PRE-HEARING STAFF ANALYSIS

Rezoning Petition No. 2008-066

Property Owner:	Financial Enterprises III Limited Liability Company 8 th and Main Parking Associates, LLC
Petitioner:	Financial Enterprises III Limited Liability Company c/o Martin Brill
Location:	Approximately 6.50 acres located on the northwest corner of N. Tryon Street and W. W.T. Harris Boulevard
Center, Corridor, or Wedge:	Corridor
Request:	CC, commercial center to CC S.P.A, commercial center site plan amendment; B-1SCD, shopping center district to CC, commercial center

**SITE PLAN/
TECHNICAL
DATA SHEET**

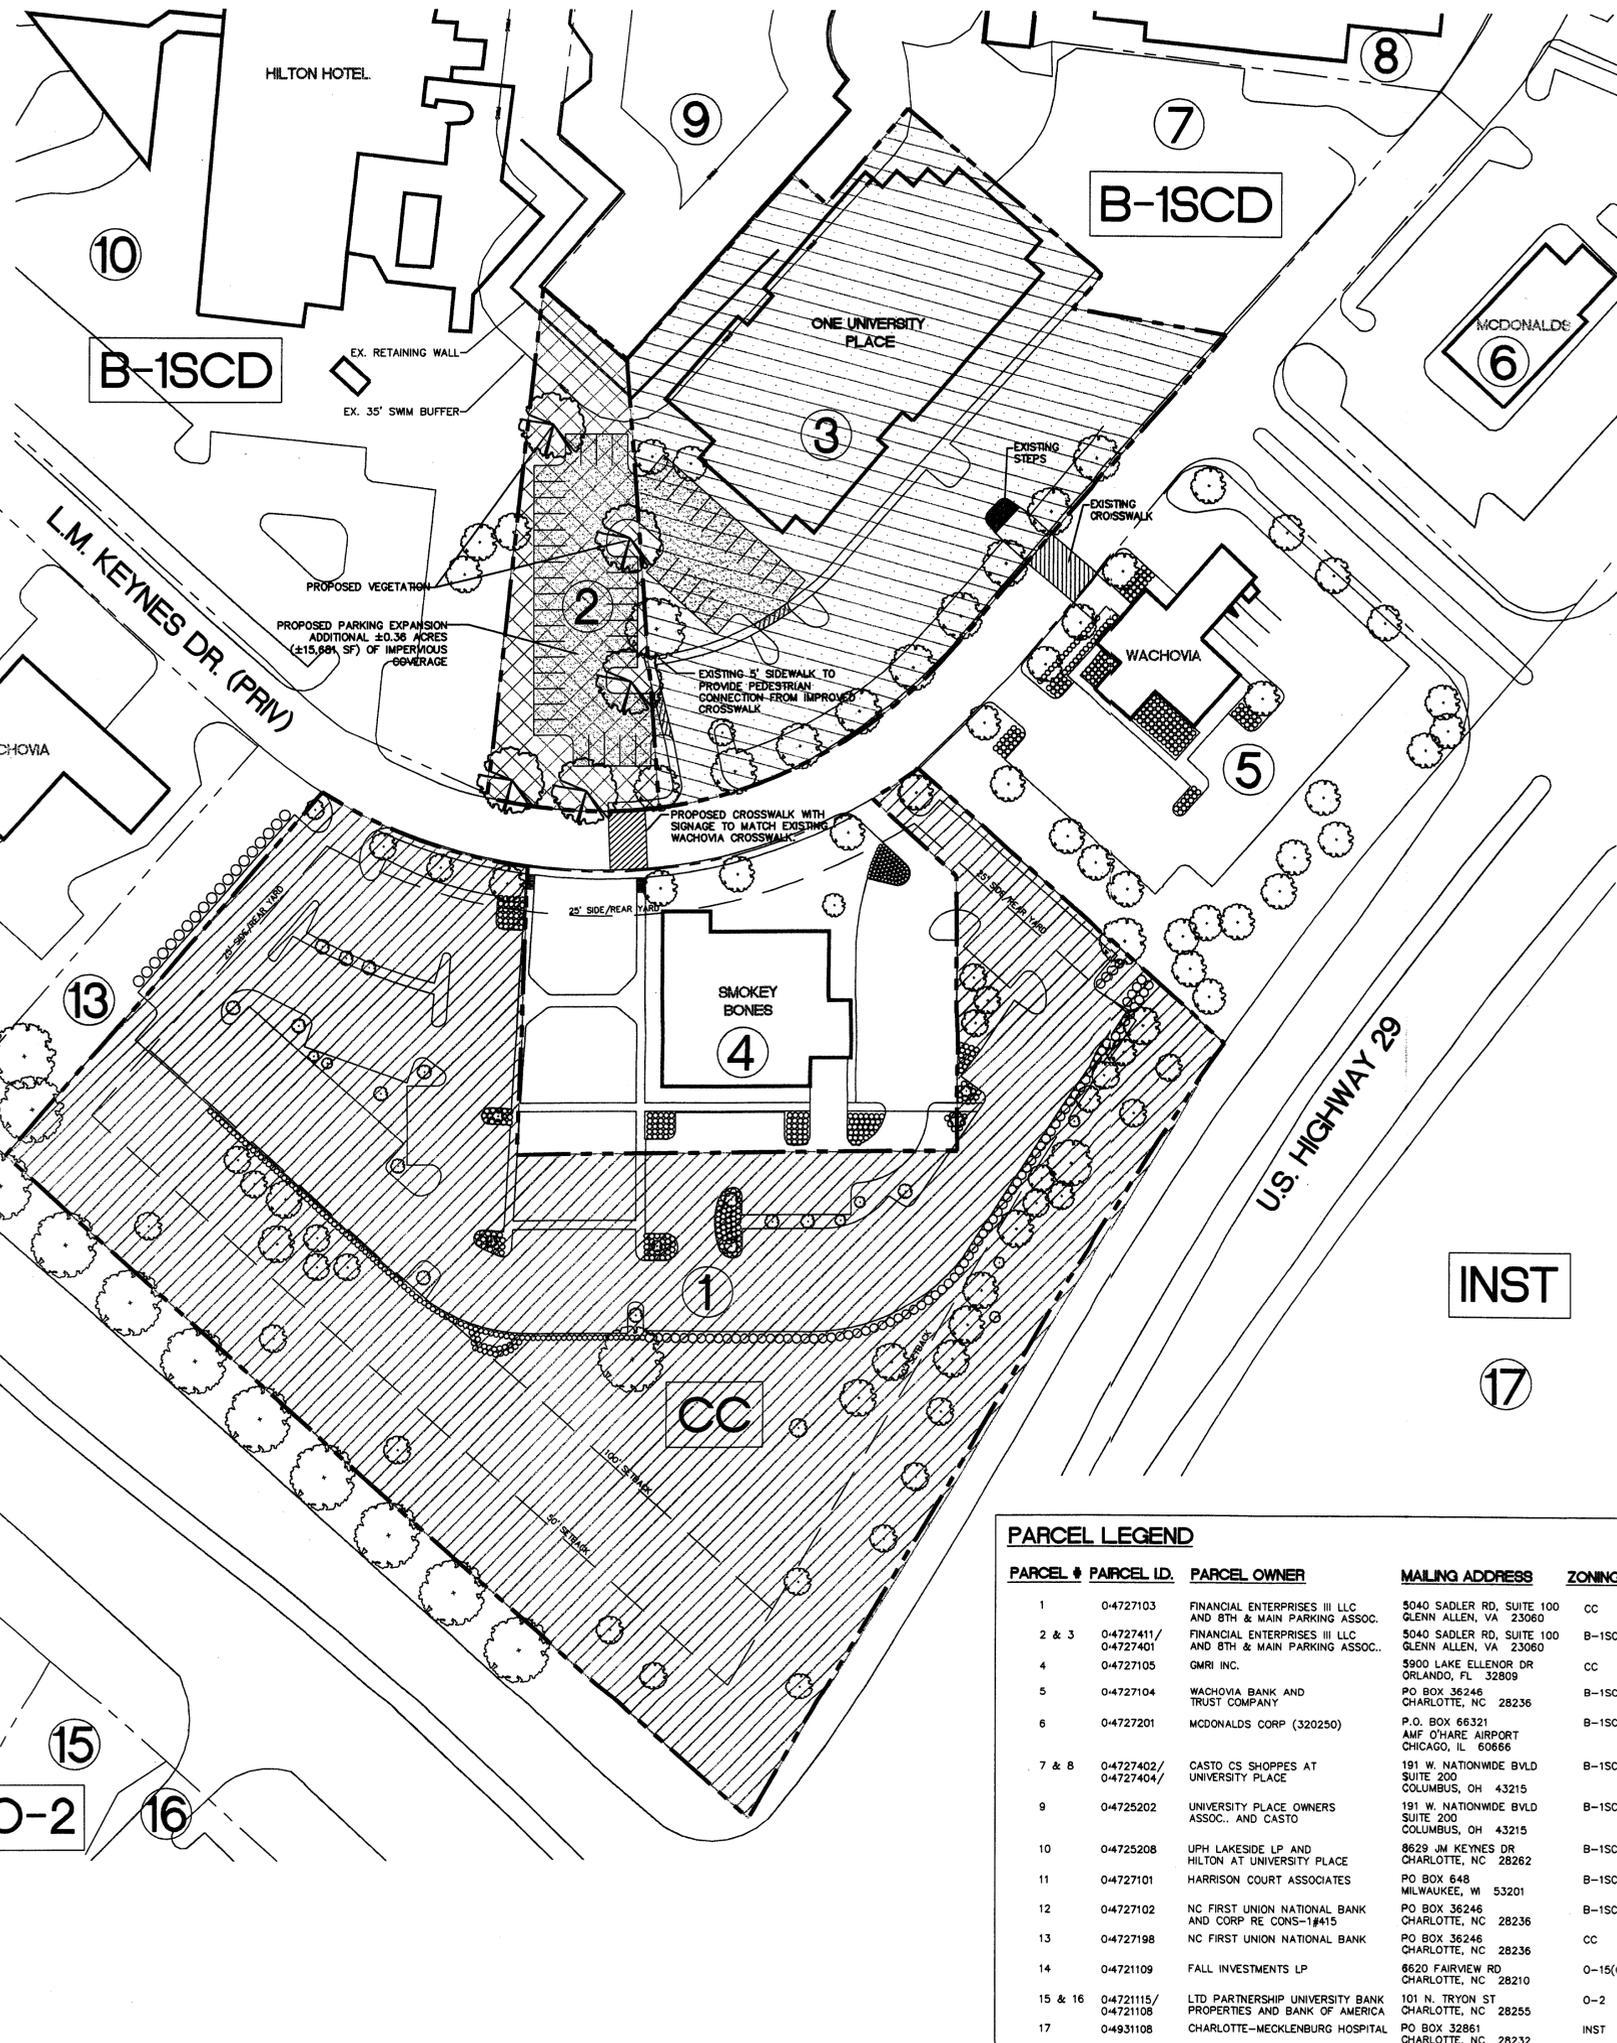
- Curb and gutter and six-foot sidewalk need to be constructed along the site's North Tryon Street frontage.
- A ten-foot shared bike/pedestrian trail needs to be constructed along the site's W.T. Harris Boulevard frontage.

The City of Charlotte Storm Water Services (SWS) has requested that the petitioner add a note to the site plan regarding compliance with the Charlotte City Council approved and adopted Post Construction Controls Ordinance.

- The petitioner should remove the note on the site plan regarding the potential inclusion of an additional 7-8 parking spaces, and revise parking calculations to identify a maximum number of new parking spaces.

- The site plan shows a proposed four-foot sidewalk along a portion of J.M. Keynes Drive. The petitioner should revise the site plan and amend sidewalk width to five-feet.
- Add additional large maturing and small trees in 100-foot setback along Harris Boulevard and Hwy 29.
- All CDOT and storm water notes should be added to the site plan.
